Fire Marshal Pre-application Comments

Project: Crytyl 39 lot long plat
Site Address: N Pfenning Rd
Permit#: EX25-008
Occupancy Type: Residential Platt
Date: 07/29/25

Date: August 6, 2025
To: Zach Torrance-Smith, Kittitas County Planning
From: Craig Jones, City Development Coordinator *CJ*
Through: Derek Mayo, City Engineer *DKM*
Re: Plat comments for Pfenning 39 lot Plat LP25-00004

Fire Marshal comments
Pfenning Road
LP-25-00004

W
A
T
E
R

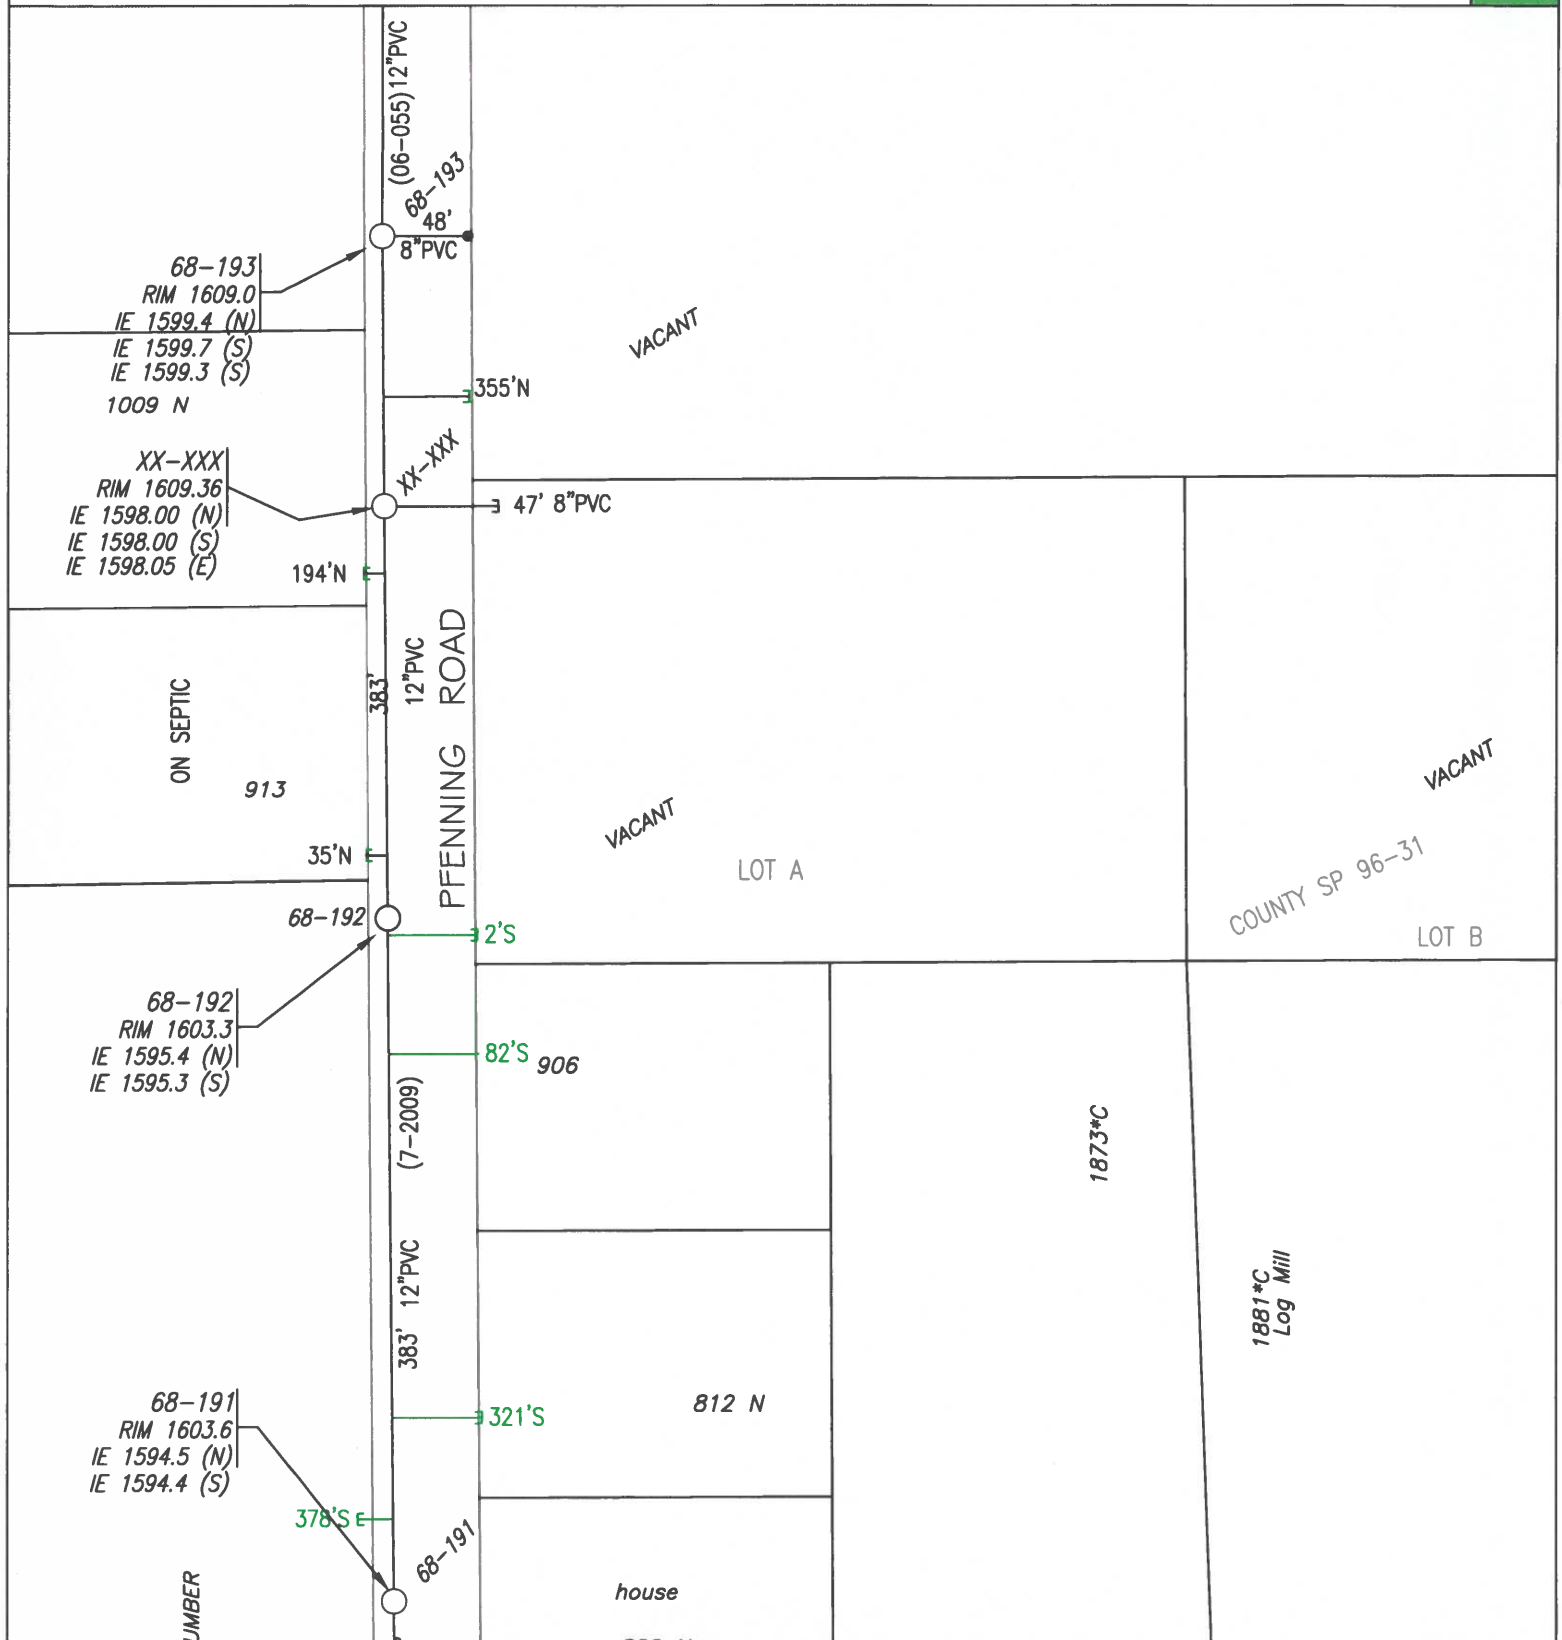
The water main available to serve this development is a 12" Ductile Iron main that runs in Pfenning Rd. There is an 8" existing stub in the proximity of the proposed access road. The developer will need to build an 8" water main on all the proposed interior roads. Each lot will need a separate water service. The maximum number of lots that can be served by one water connection is 40 lots. Larger water service lines may be required for any lot that will have a residential fire sprinkler system. Looping of an interior water main may be needed depending on fire flows. See attached utility map.

S
E
W
E
R

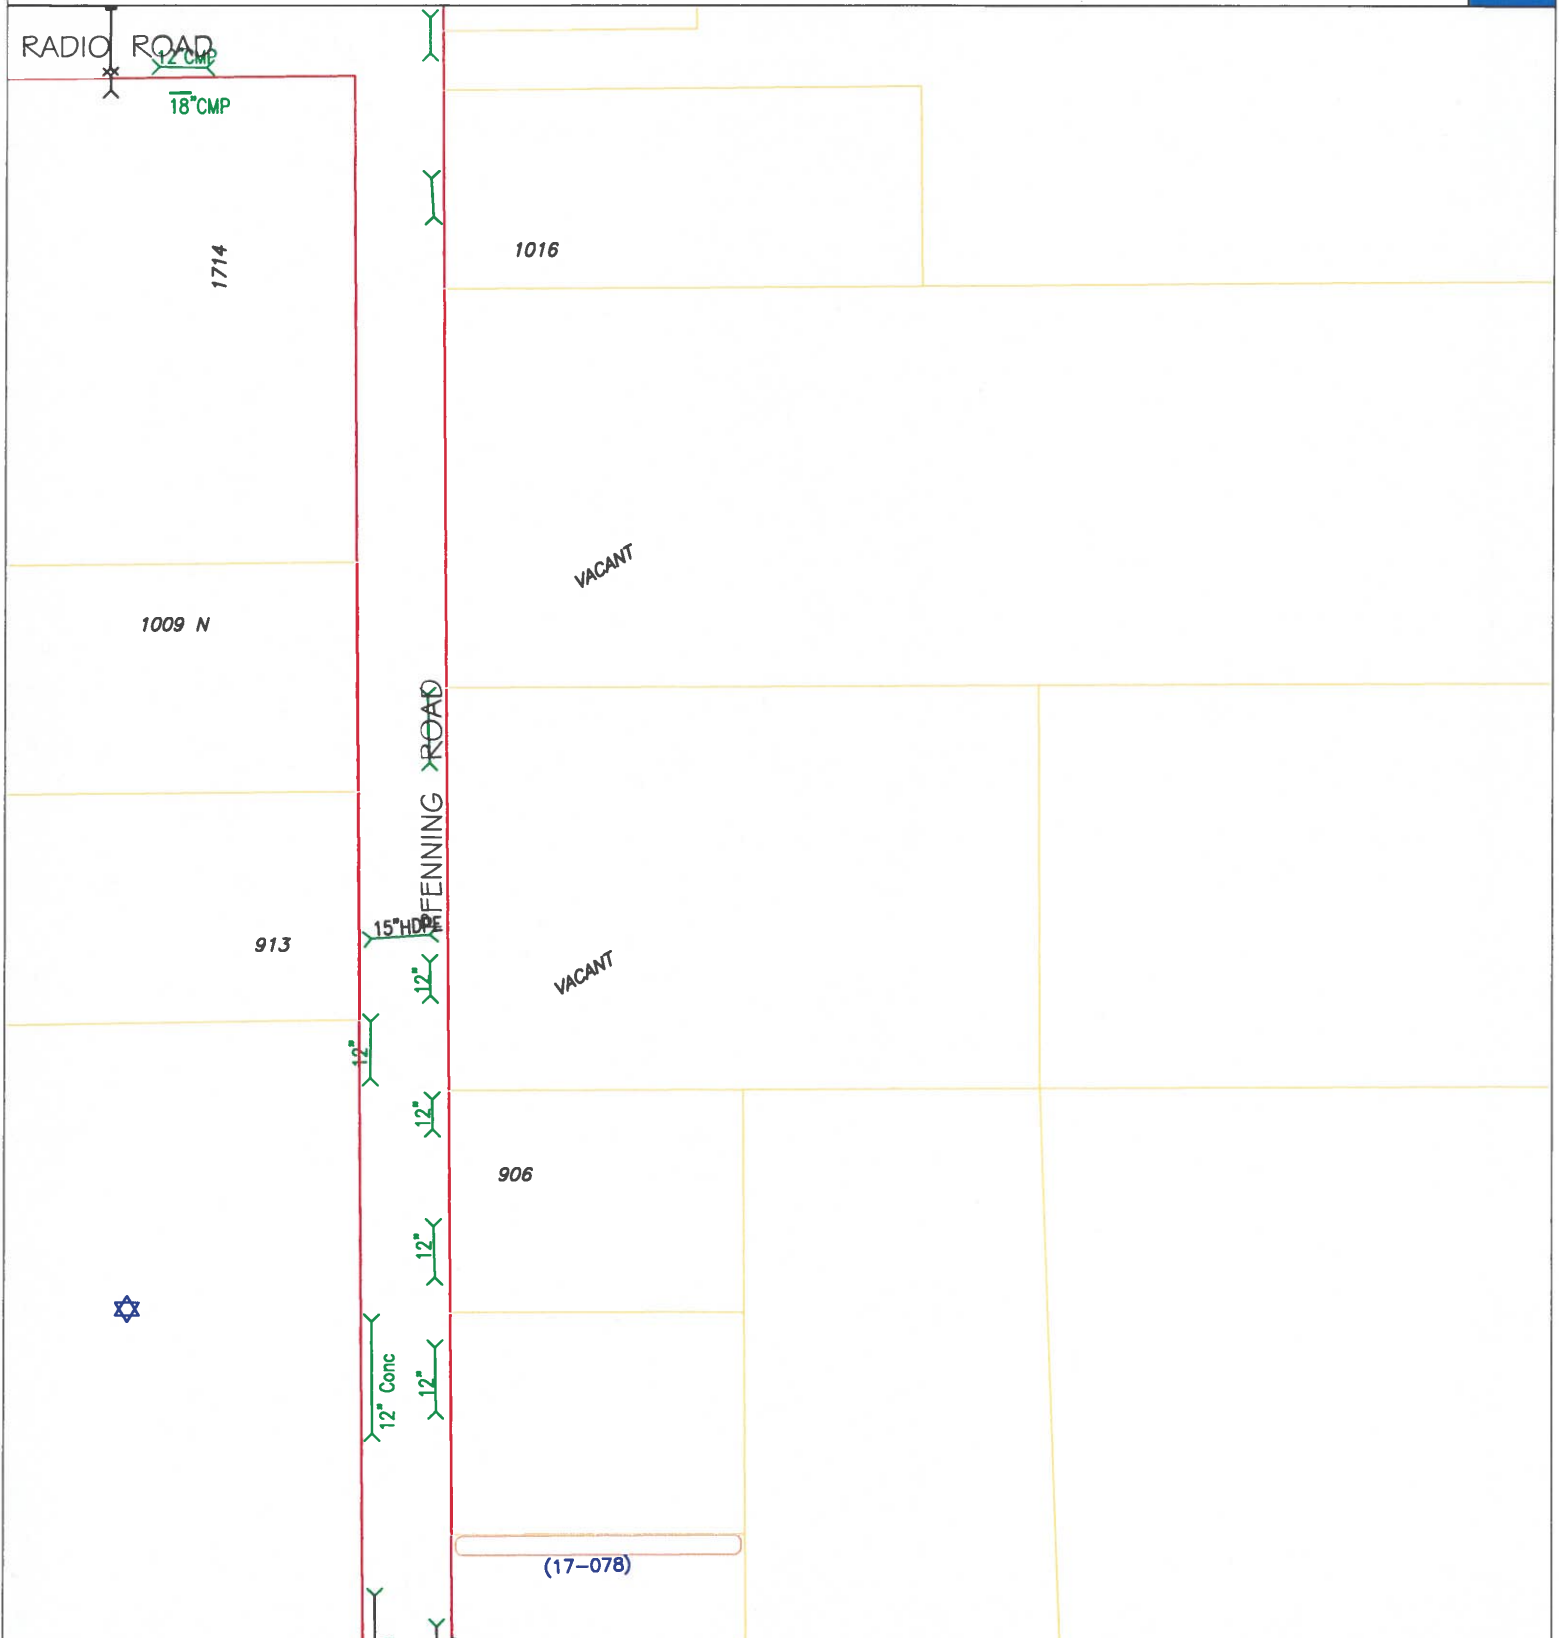
The sewer main available to serve this development is a 12" PVC main in Pfenning Rd. There is an 8" existing stub in the proximity of the proposed access road. The developer will need to install 8" sewer mains on the interior roads and side sewer stubs to each lot. See attached utility map.

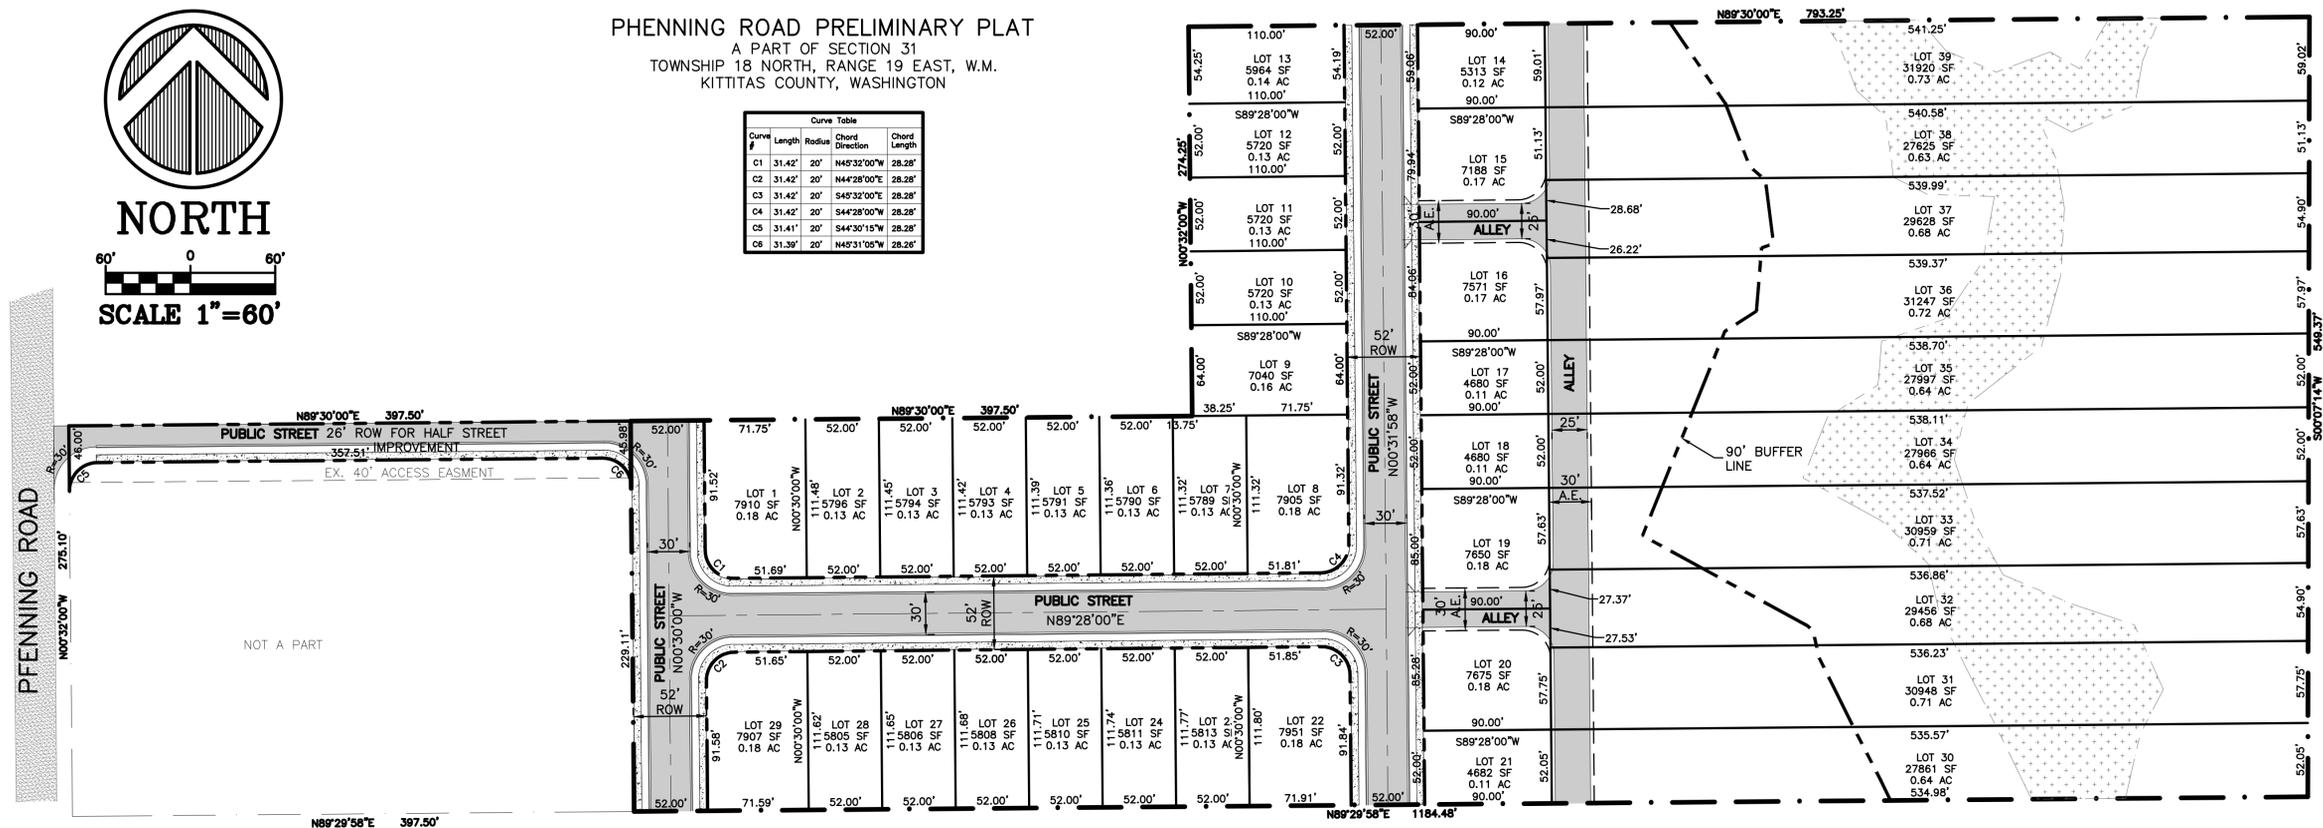
- 5) Current plat design only has one fire access road. Per Appendix D of IFC Section D107 One- or two-family developments. D107.1 ...Developments of one- or two-family dwellings where the number of dwellings exceeds 30 shall be provided with two separate and approved fire access roads. As AHJ for city of Ellensburg it would be acceptable to plat the 39 lots and limit building to 30 dwelling units until such time that it can be shown that future development will connect to secondary fire access road or any acceptable alternate means and method which would reduce the hazard.

Fire hydrants are required for this application. Either the indicated number or the spacing of the fire hydrants is inadequate. Provide fire hydrants such that the maximum spacing between hydrants does not exceed 500 feet and such that no lot or parcel is in excess of 250 feet from a fire hydrant as measured along approved fire apparatus access roads.

Developments exceeding 30 lots shall be provided with two separate and approved fire apparatus access roads. There are exceptions to this code section that can be discussed.
